From: Adrian Dowd
Sent: 25 January 2021 13:09
To: Planning <planning@ribblevalley.gov.uk>
Cc: John Macholc <John.Macholc@ribblevalley.gov.uk>
Subject: 3/2020/1056 - Chipping Congregational Church

Application 3/2020/1056
Chipping Congregational Church

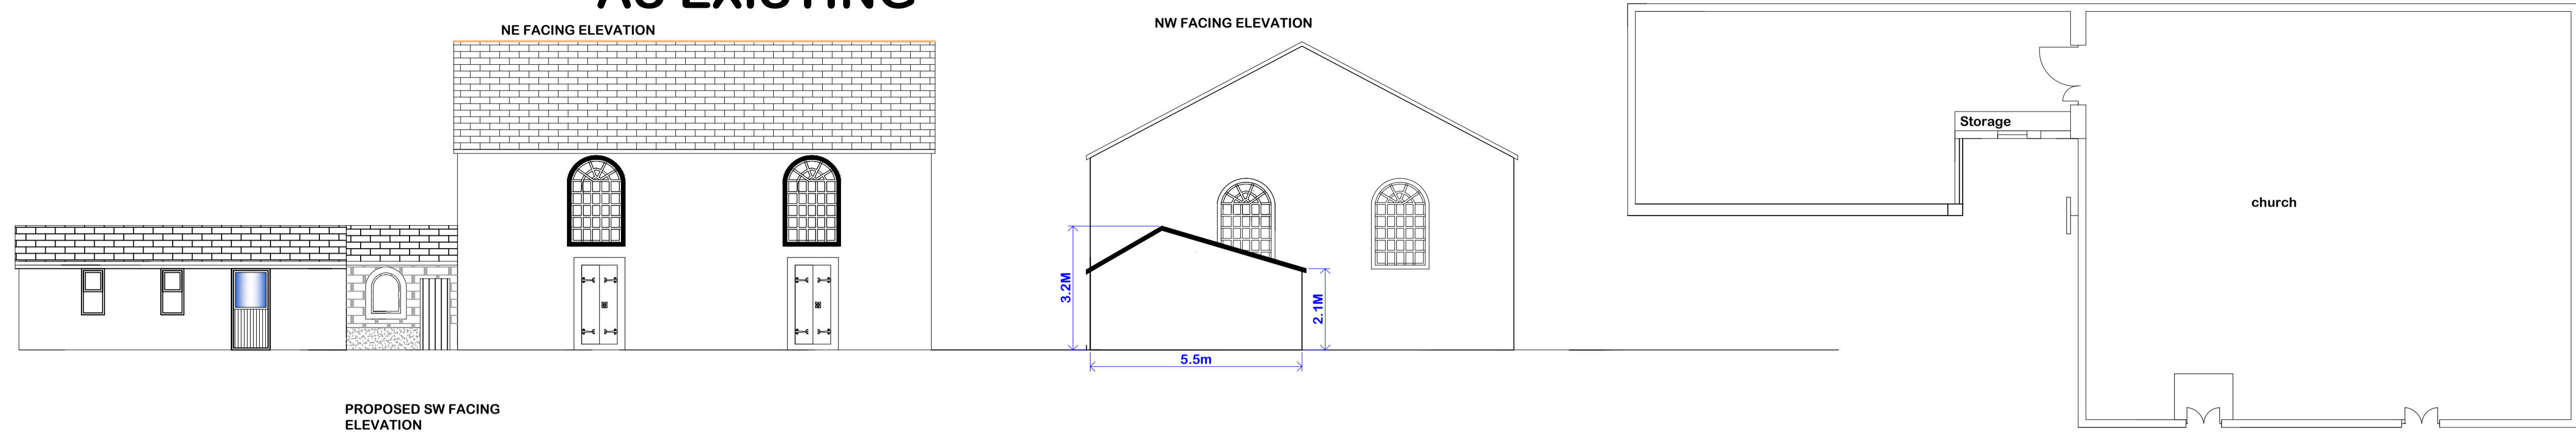
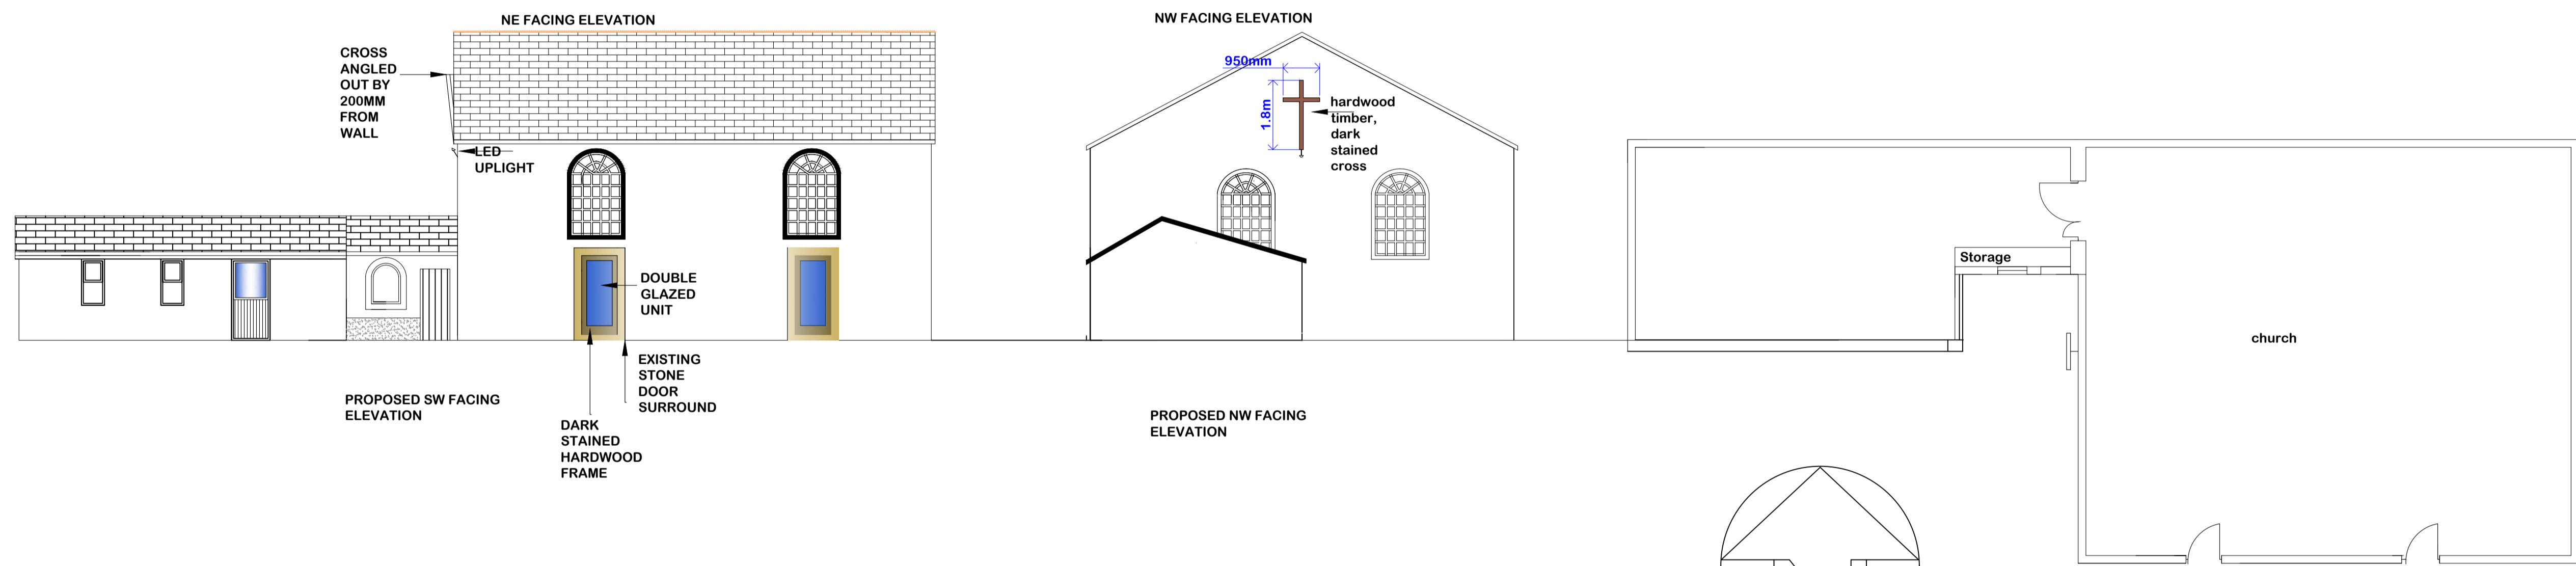
No information submitted on location and means of attachment to listed building or lighting unit impact. Need to understand impact to historic fabric.
No joiners report submitted identifying the state of repair of the doors.

Windows and doors (including materials and form) are intrinsic to the interest and character of this relatively plain building and reflect how the building was accessed and used inside. No ‘clear and convincing justification’ (see NPPF 194) has been submitted for removal of the historic solid timber doors (can they be repaired/upgraded with draught excluders?). The proposed fully glazed openings are overtly modern, incongruous and conspicuous and harmful to the special architectural and historic interest of the listed building, the character and appearance of Chipping Conservation Area and the cultural heritage of the AONB.

The NW elevation is very plain and is only distinguished by two mid-height symmetric multi-paned windows. The illuminated cross below the apex will draw attention away from this design. The guidance of the Chipping Conservation Area Appraisal Management Guidance appears relevant “satellite dishes, meter boxes, burglar alarms, security and other floodlighting, video cameras, and central heating and other flues should be located carefully in a visually unobtrusive position away from the principal elevation”. The impact to the historic fabric has not been identified. Can the cross be attached to the gable of the modern single-storey extension? Can increased use of the notice-board be made?
